October 4, 2022

Re: Public Comment Overview - File No. 2207-019 / 6950 SE Maker Street / Parcel
No. 9350900620

We are commenting on this proposed project because we believe the GFA calculation and the existing grades designated by the applicant do not comply with the Mercer Island City Code (MICC). We also have several concerns and questions for the City that pertain to the geotechnical and storm drainage report of which we request be answered. Additionally, due to the complexity of the proposed project, site considerations by the geotechnical consultant, and tight confines of Maker Street, we are requesting the City require a Construction Management Plan be filed. And lastly, based upon our understanding, the MICC tree code may have been violated, and we've provided information pertaining to that issue.

JOB NUMBER:	210007
DATE:	05/27/2021
DRAFTED BY:	RSN
CHECKED BY:	TBR / JGM
SCALE:	1" = 10'
REVISION HISTORY	
SHEET NUMBER	1 OF 1

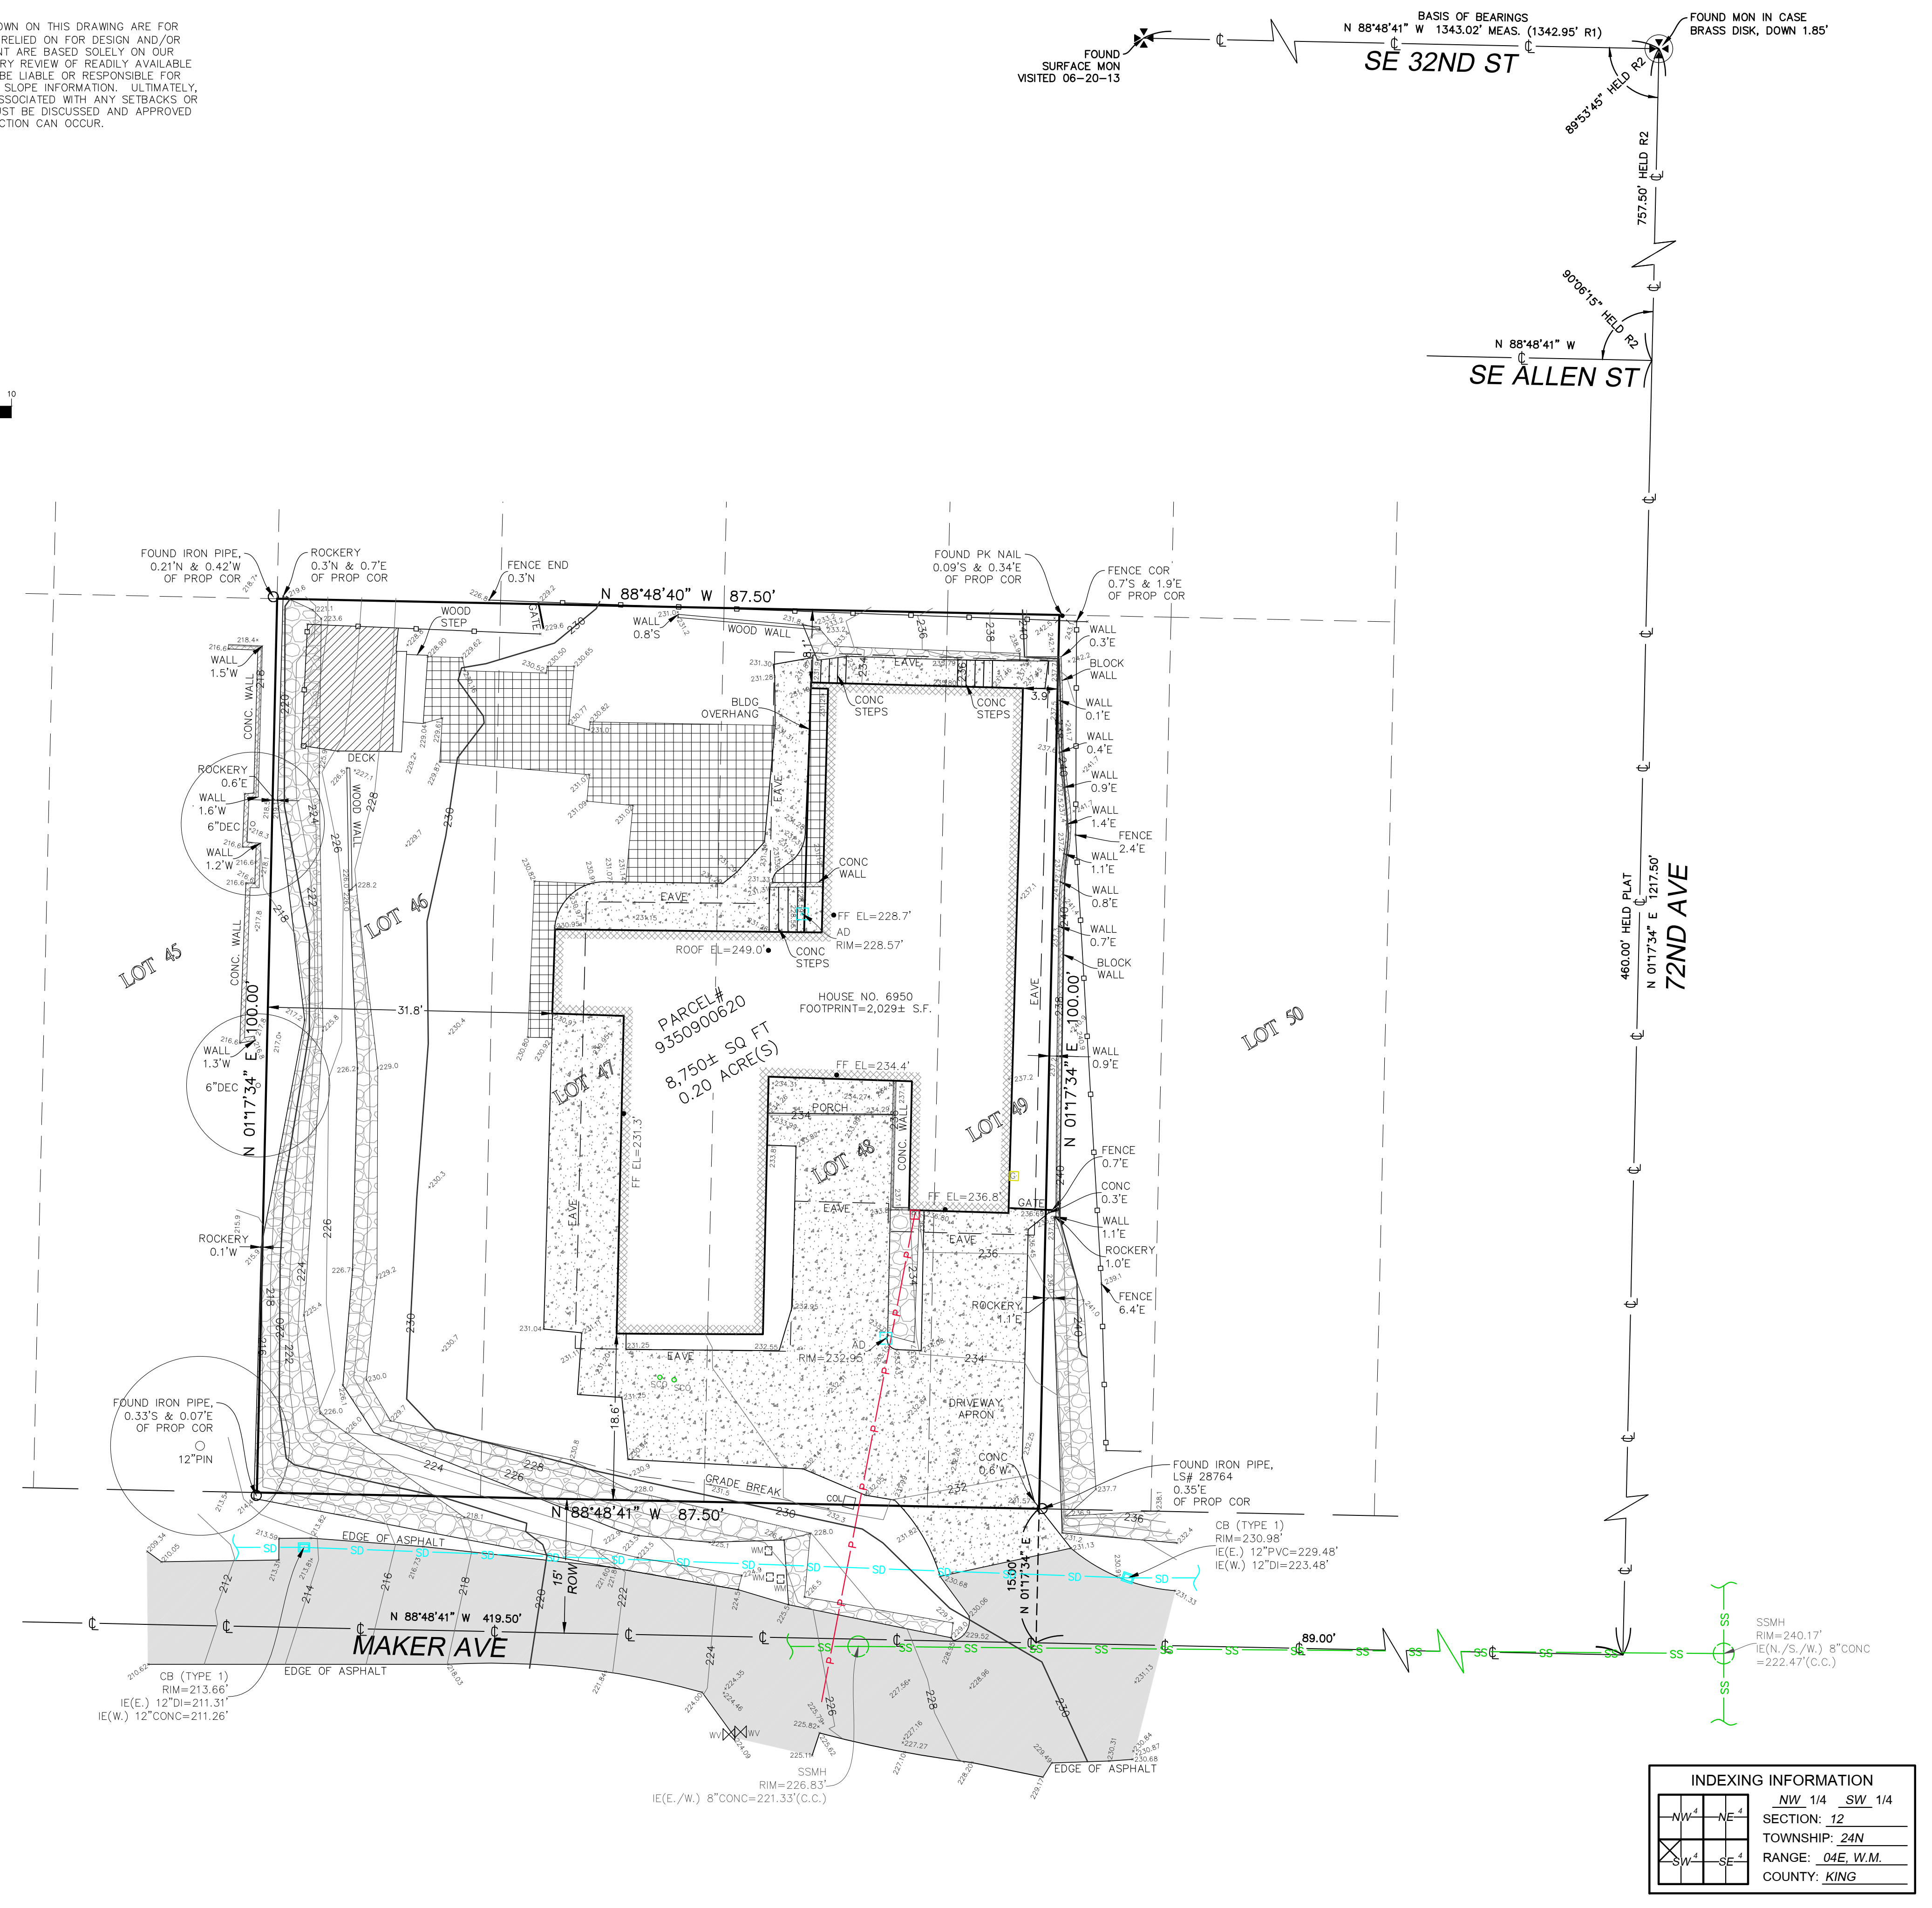
(Please note, we do not agree that most of the spot elevations and contours shown on Terrane sheet 1 of 1 meet the MICC definition of existing grade, however we did use them to illustrate our points above.)

A majority of the spot elevations and contours on the survey plan, Terrane sheet 1 of 1, which are designated by the applicant for design of the proposed project, do not meet the MICC definition of *existing grade* and more extensively, *alteration* and therefore, do not comply with the MICC.
